Arun District Council
Arun Civic Centre
Maltravers Road
Littlehampton
West Sussex BN17 5LF
Planning & Building Control General Enquiries
Tel: (01903) 737756 Fax: (01903) 730442
Dx: 57406 Littlehampton
Minicom: 01903 732765
e-mail: planning@arun.gov.uk
website: www.arun.gov.uk/planning

Application No: BE/59/20/A
Site Address: Land at Phase 1A Oldlands Farm Bognor Regis PO22 9NN
Description of works: Installation of 2 x identical totem signs.

Drawing Title:
PROPOSED SHARED ESTATE
TOTEM SIGNAGE

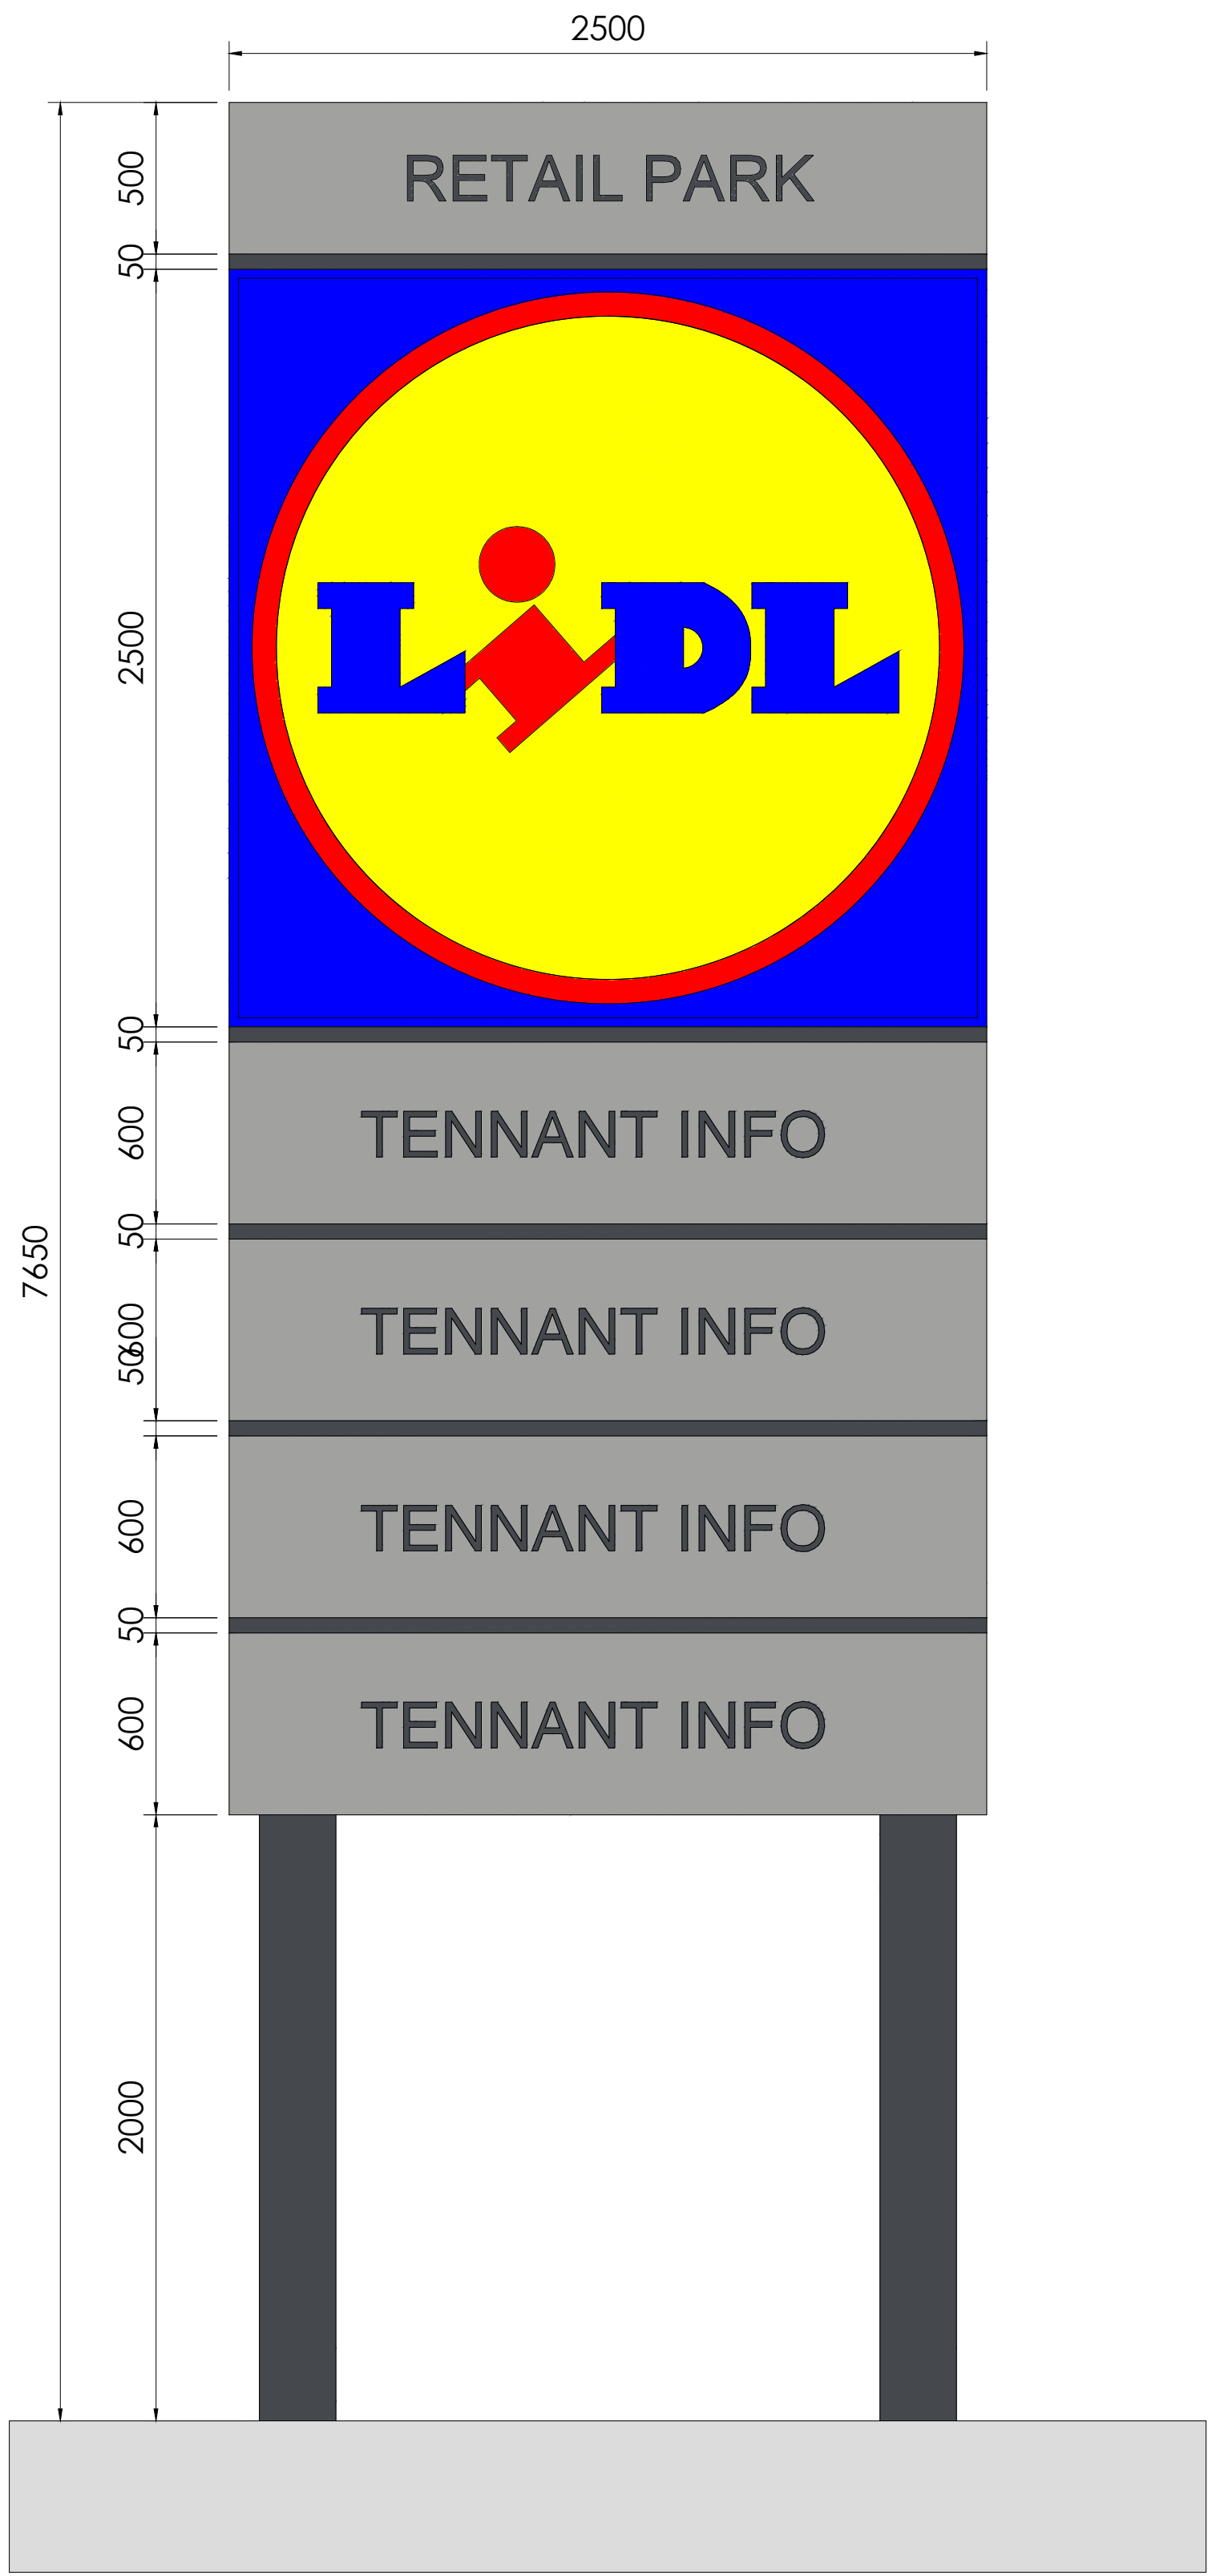
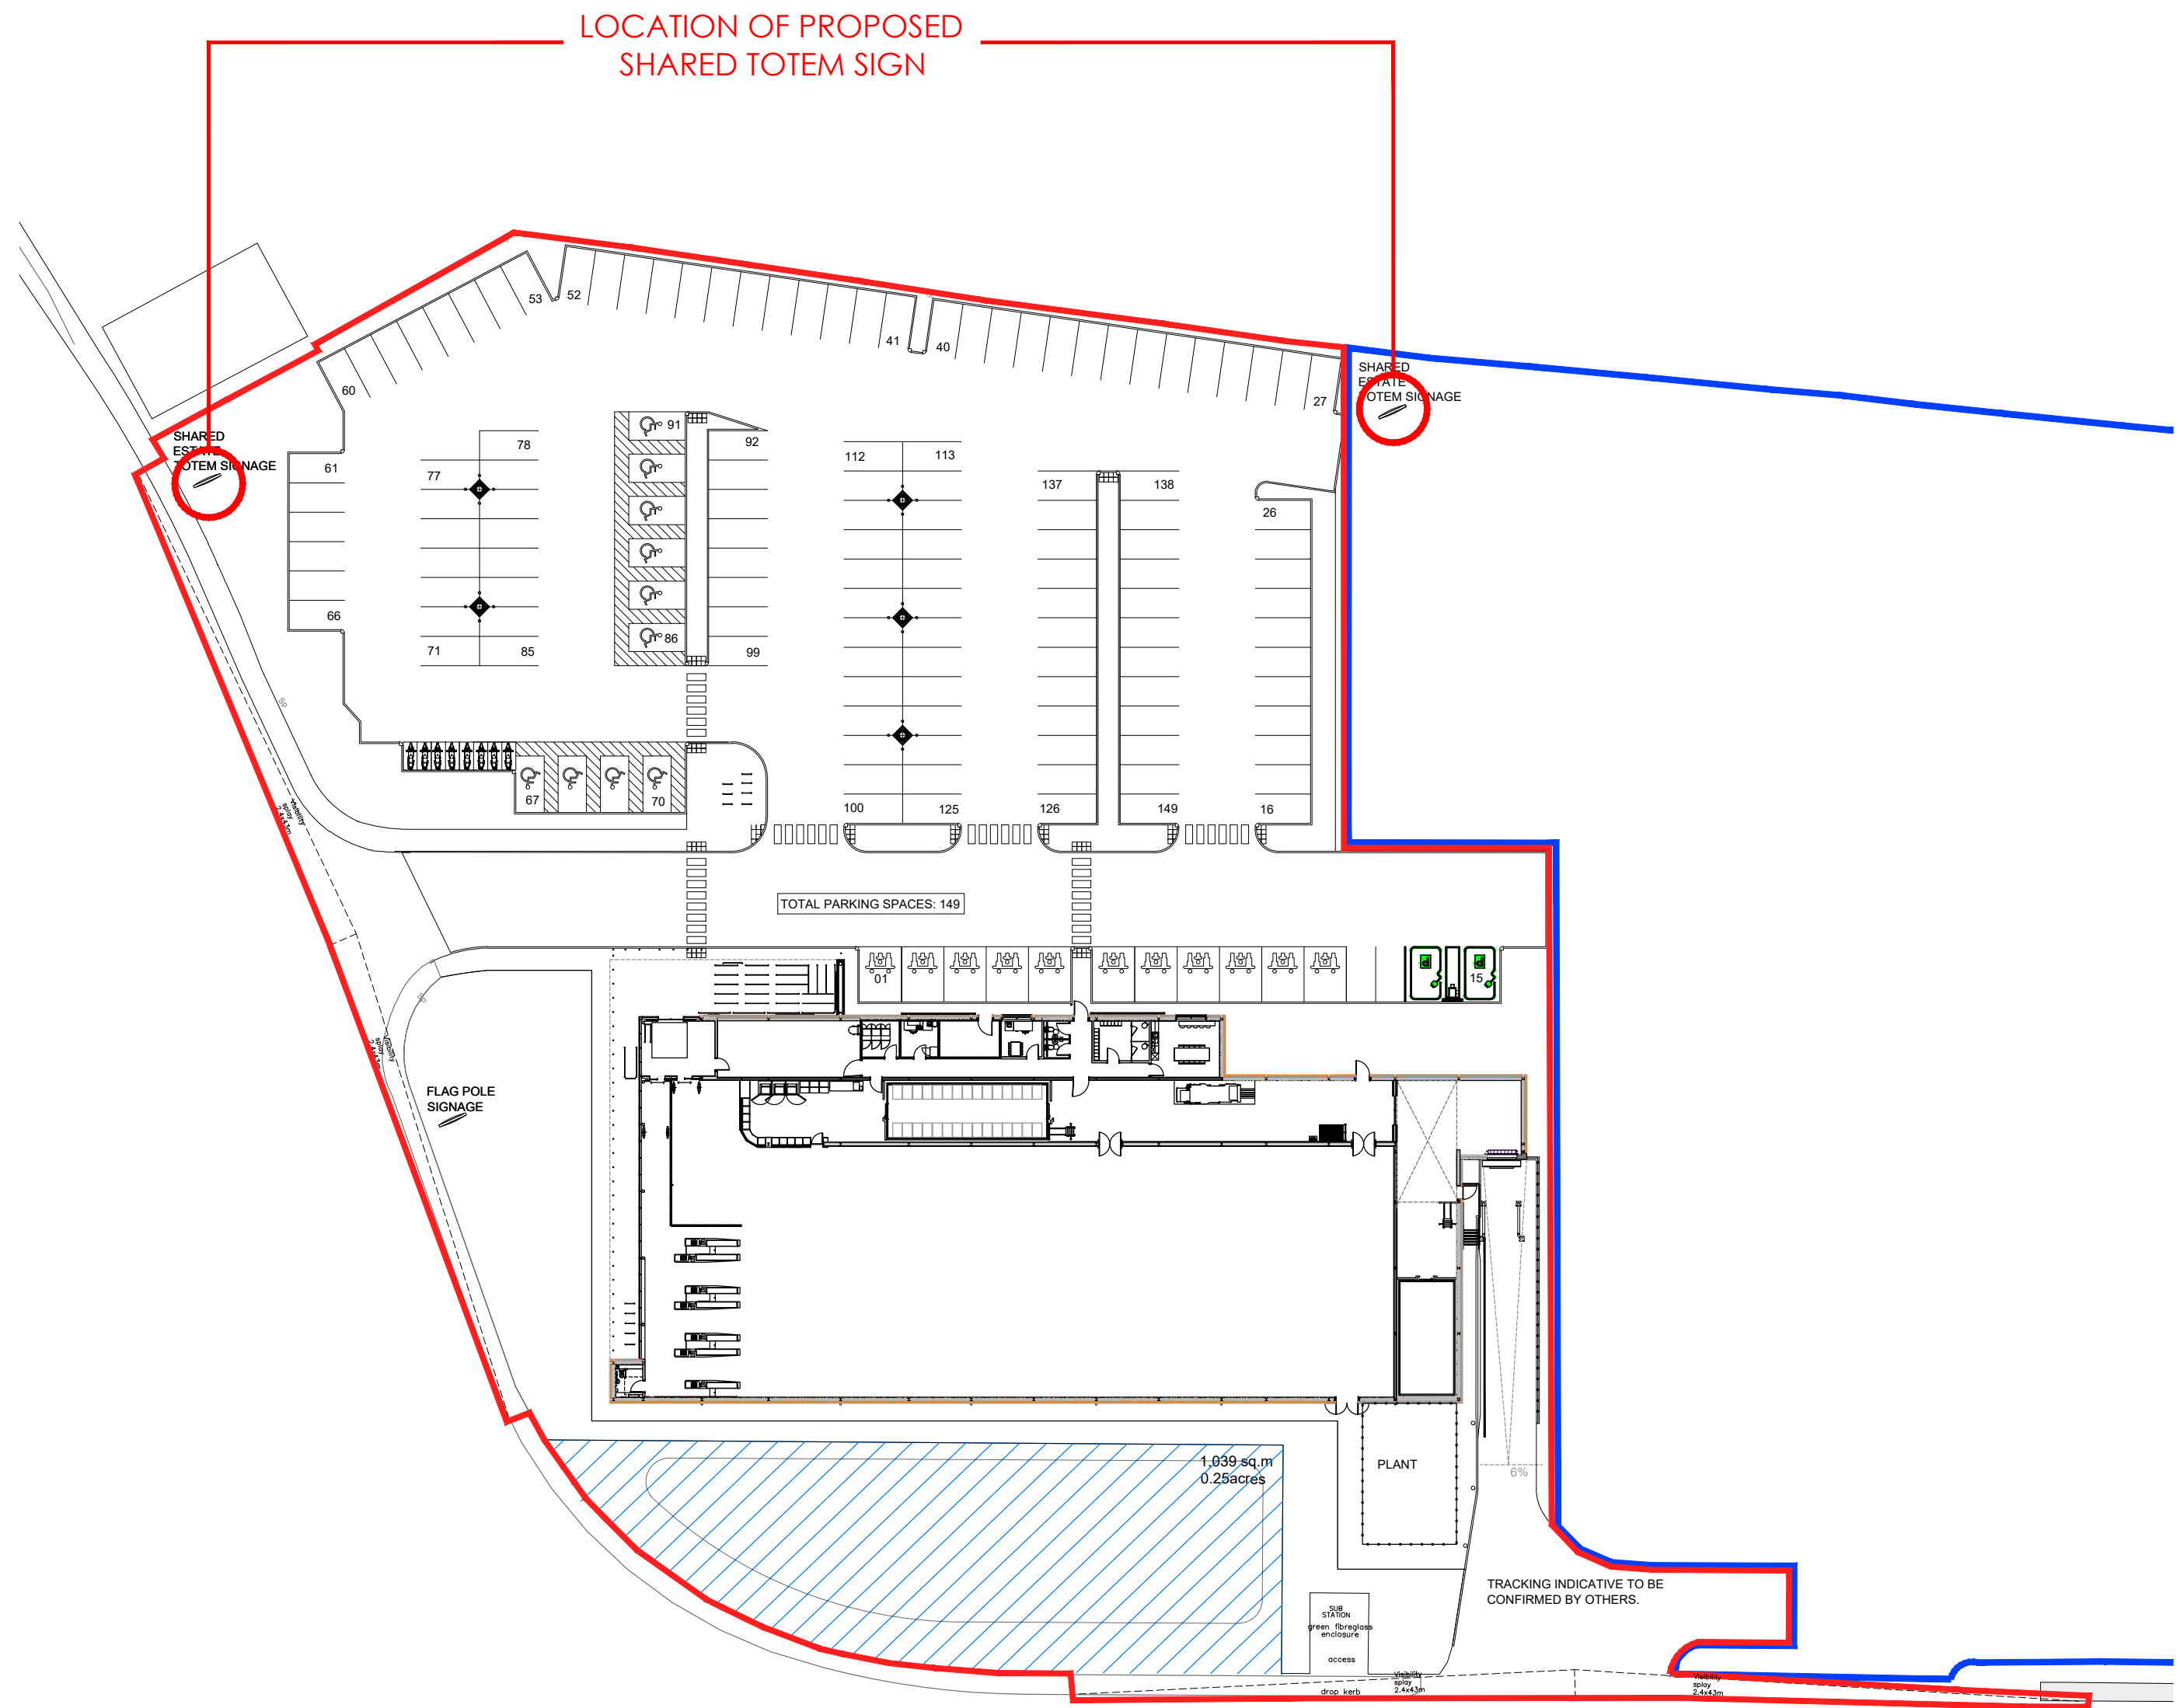
No Objection but would comment that the illumination of the totem signs does not impact on the residents of Shripney
